**DELEGATED DECISION FOR APPLICATION FOR CERTIFICATE OF
LAWFUL DEVELOPMENT**

Reference no.: 2021/CL/91818/E

Site: Primrose Farm, Crossley Lane, Mirfield, WF14
0NR

Description: Certificate of lawfulness for proposed alterations to
stables to create dwelling forming annex accommodation associated with
Primrose Farm, Crossley Lane, Mirfield, WF14 0NR

Plans and Elevations as Proposed

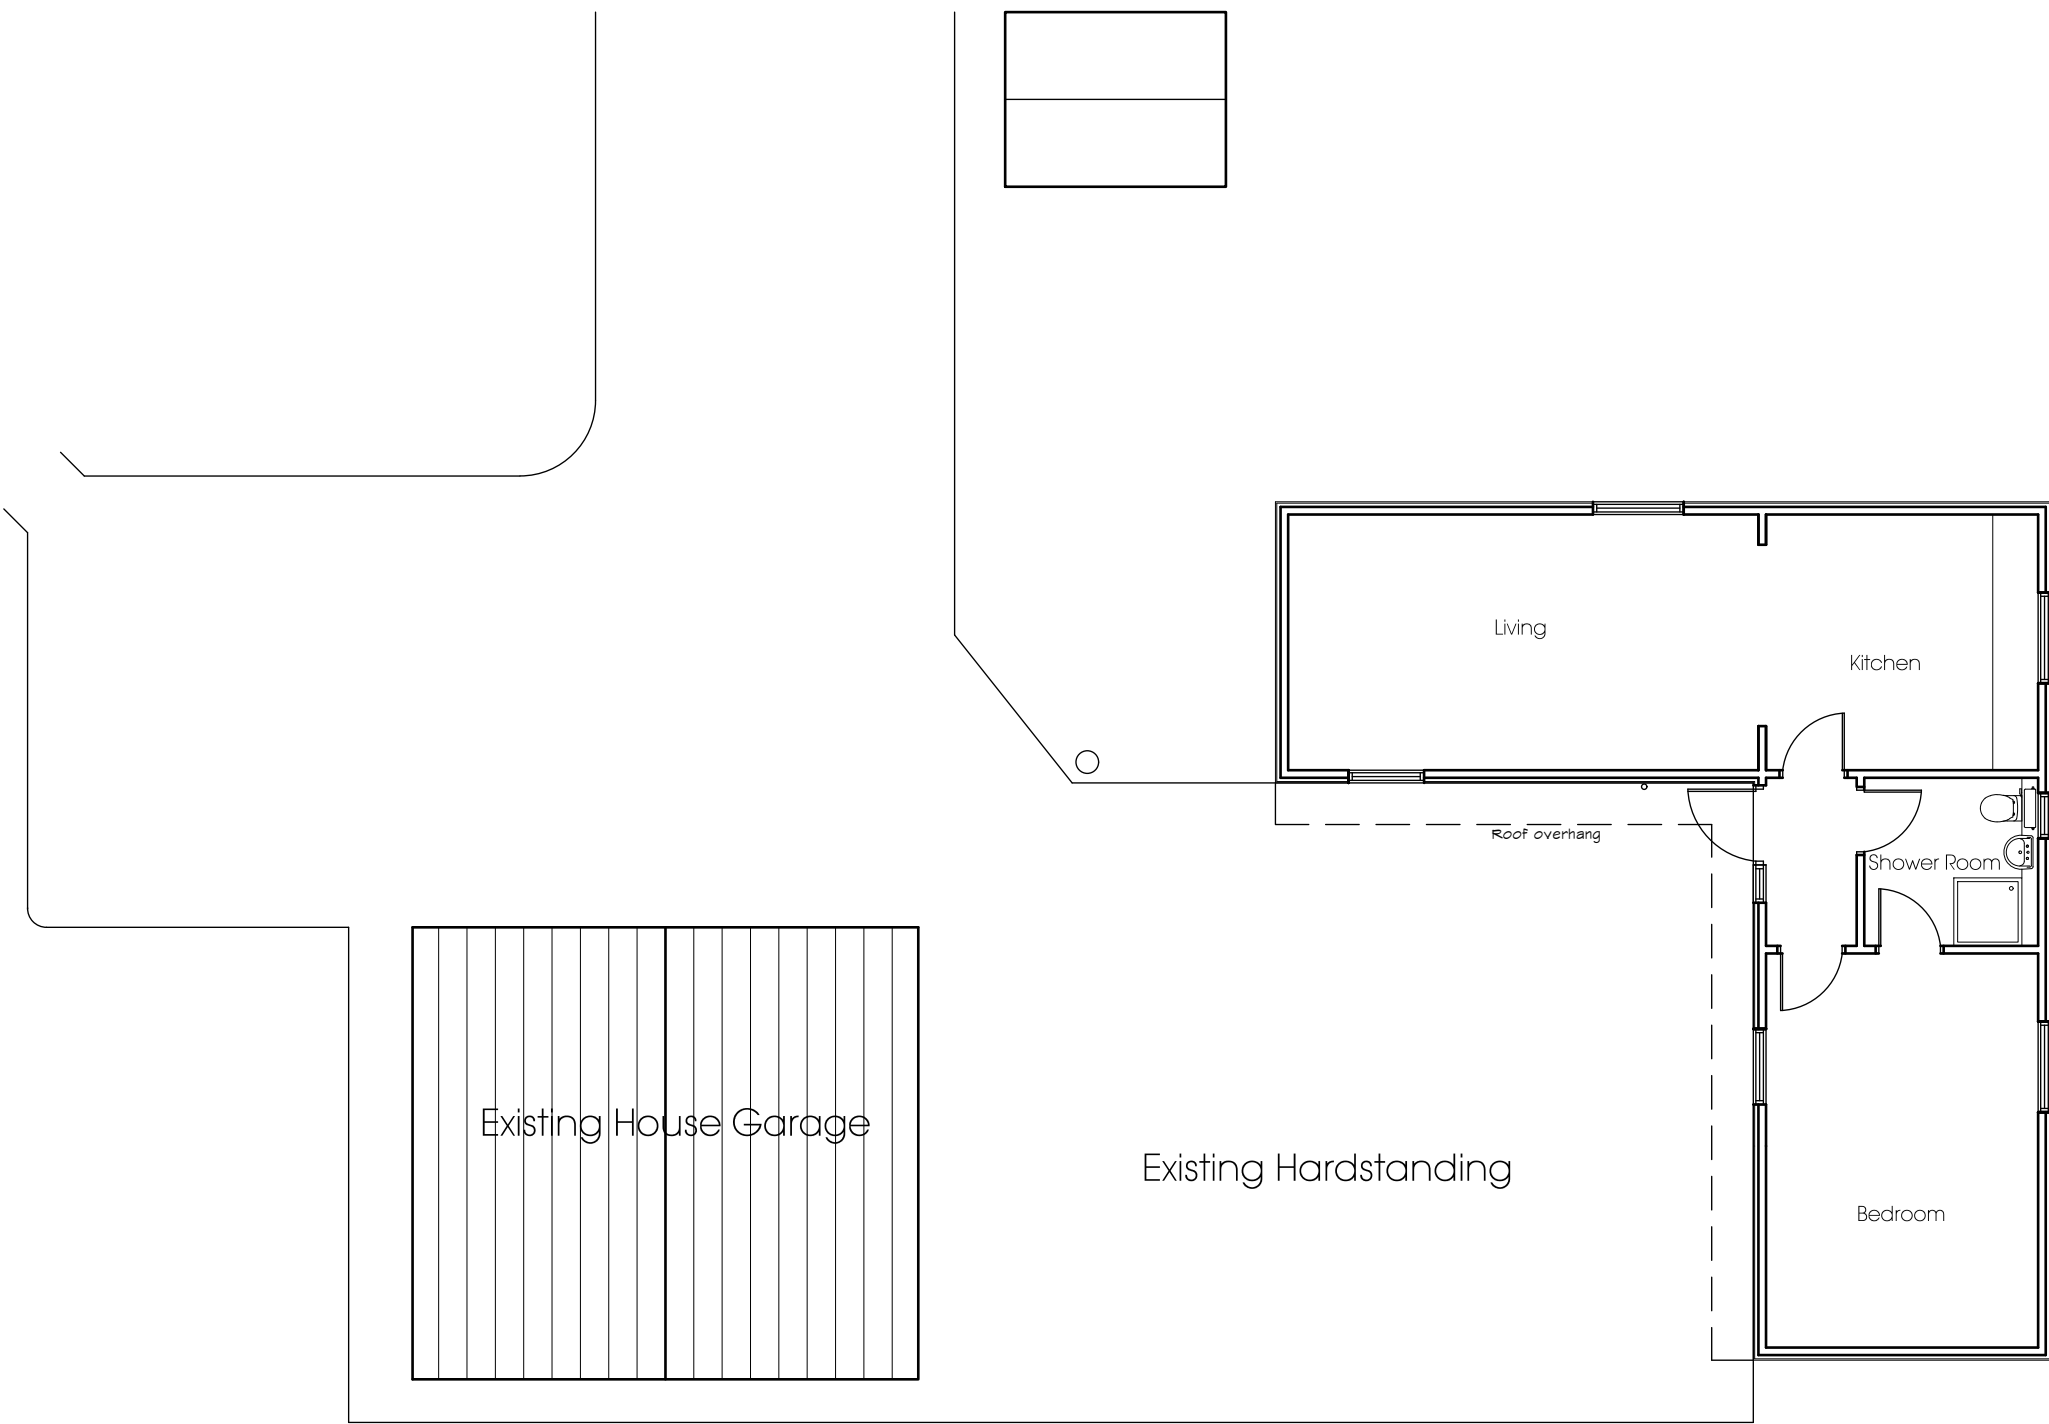
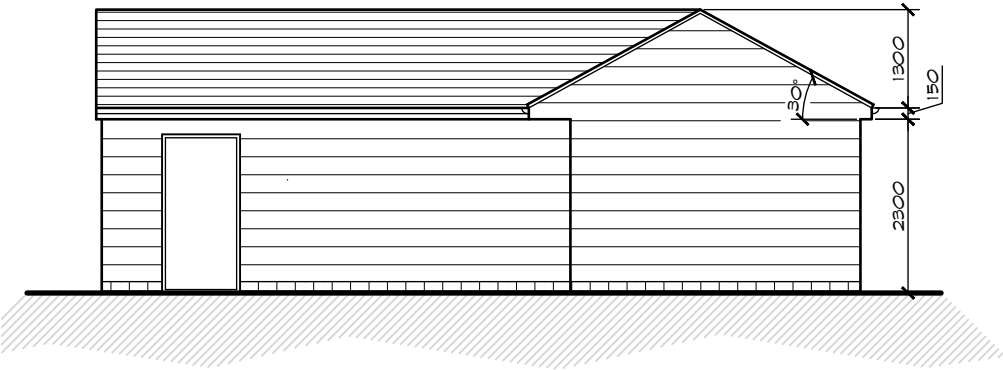
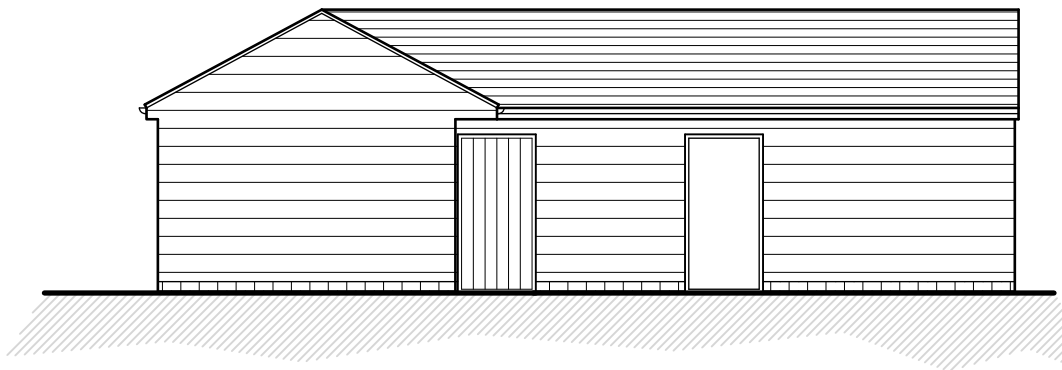
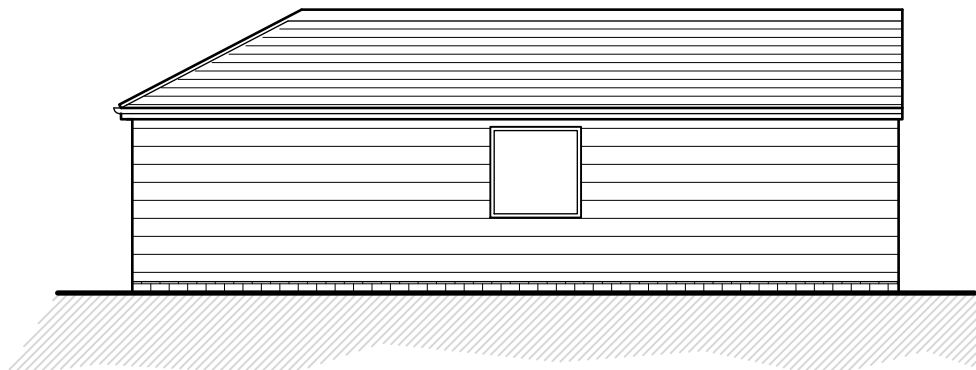
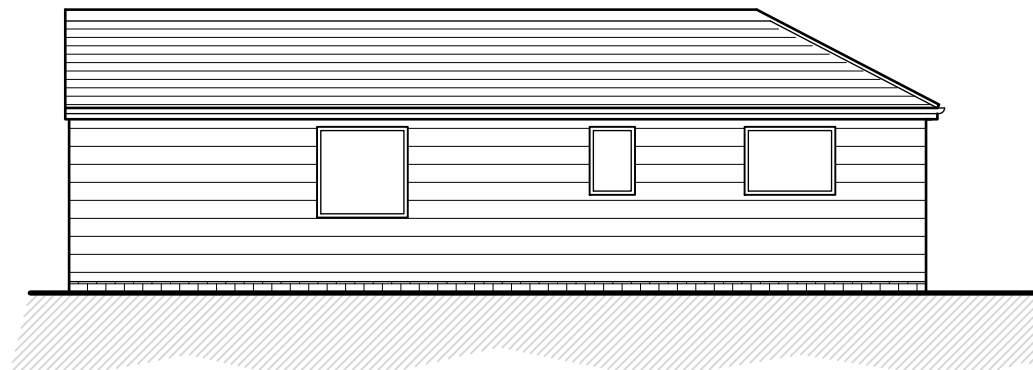
In this case and judging from proposed floor plans there is little doubt via the proposed floor plan that the stable will be capable of providing amenities essential for day to day living accommodation such as cooking, sleeping, washing, heating and toilet facilities and is therefore providing facilities required for day-to-day existence and capable of independent living accommodation. On this basis it is considered the proposed use for the stable block is a dwellinghouse². Furthermore, the stables are situated in a position some 26m from the main house with a driveway separating this from the main house and garden area. The stable would essentially form a single independent unit of occupation that does not have any functional or dependable link to the main house other than as accommodation by relatives to the dwellinghouse as stated in the applicants description.

Independency may arise from arrangements whereby the stable has a physical separation from the existing dwellinghouse and that no parts of the dwellinghouse are required for the stable use, for example access via the existing dwelling or indivisible use of shared areas. In this respect the stable is to be sited 26m from the corner of Primrose Farm and accessible from Crossley Lane by the existing driveway. The future occupiers would be able to utilise access to the courtyard of the stable which may form garden with no practicable need to share amenity space which is located beyond the double garage. Furthermore, there is a physical separation between the stable and the main house with the position of the stable behind the garage in its own forecourt. Both the stable and existing dwellinghouse could independently exist both functionally and physically.

The proposed conversion includes the creation of new openings in the building to bring light into the rooms to be converted to residential accommodation.

Ordinarily Class E, Part 1 of Schedule 2 of the Town and Country Planning (General Permitted Development)(England) Order 2015 (as amended) provides a permitted development right to make alterations to a curtilage building required for a purpose incidental to the enjoyment of the dwellinghouse. However, it is well established that the use of a building for primary living accommodation is not an incidental use. As concluded above, the purpose of the building is not considered incidental to the dwellinghouse and new dwellinghouse is being created. As such Class E permitted development rights do not apply in this instance by reason of Class E(1)(i).

As no other permitted development right can be relied upon and as no other planning permission has been granted for the openings, this development also cannot be said to be lawful.
